Application No: M/147/21/HH
Site Address: 19 Elm Drive Elmer Middleton-On-Sea PO22 6JE
Description of works: Single storey rear extension and addition of a storey.

Thank you for your internet representation made on 7th February 2022 which has been recorded as an objection with the comments as follows:

PROPOSED FIRST FLOOR PLAN

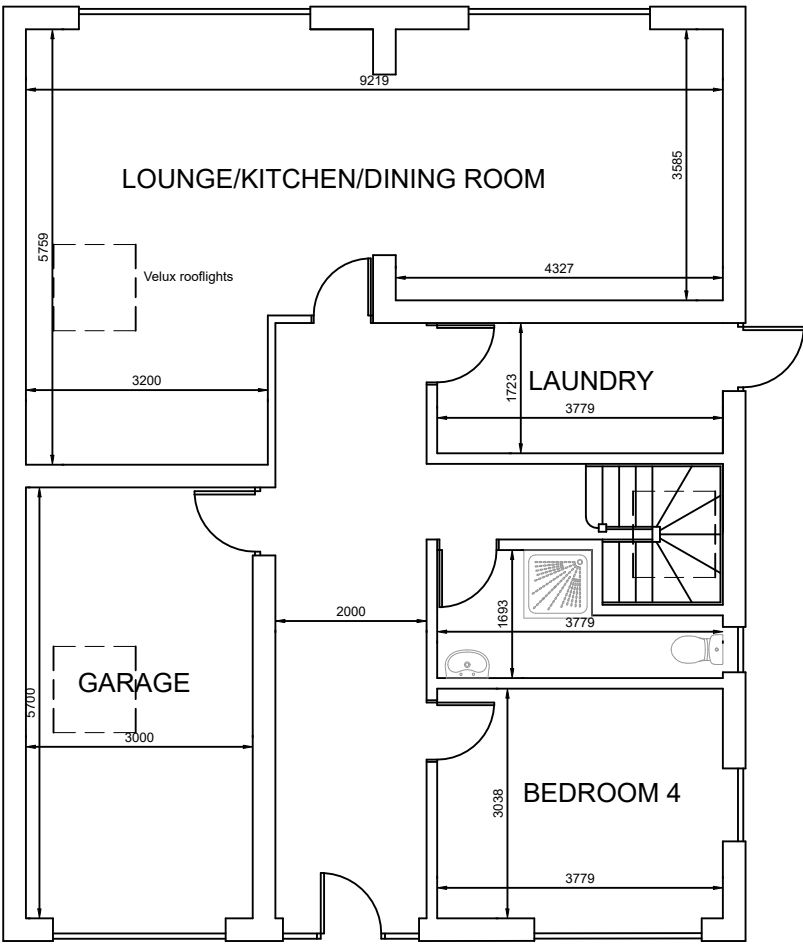
The proposed second storey will create significant overshadowing of our property, in particular to all the rooms, alongside the proposed development, including our lounge and dining room, where there is only one window.

I am very concerned about the loss of light, into all the rooms down the side of our bungalow neighbouring the proposed development, that the proposed second storey addition will cause. Having monitored the situation, we currently receive sunlight through these windows for the majority of the day. With the proposed addition of a second storey along the whole of the existing ground floor, this will block out the sunlight for most of the day, and will have a negatively consequential effect on the amount of daylight we receive into our rooms.

With the addition of the windows at the back of the proposed second storey this will also mean that we would then be overlooked, and will result in us losing our privacy in our very private garden, which is not currently the case.
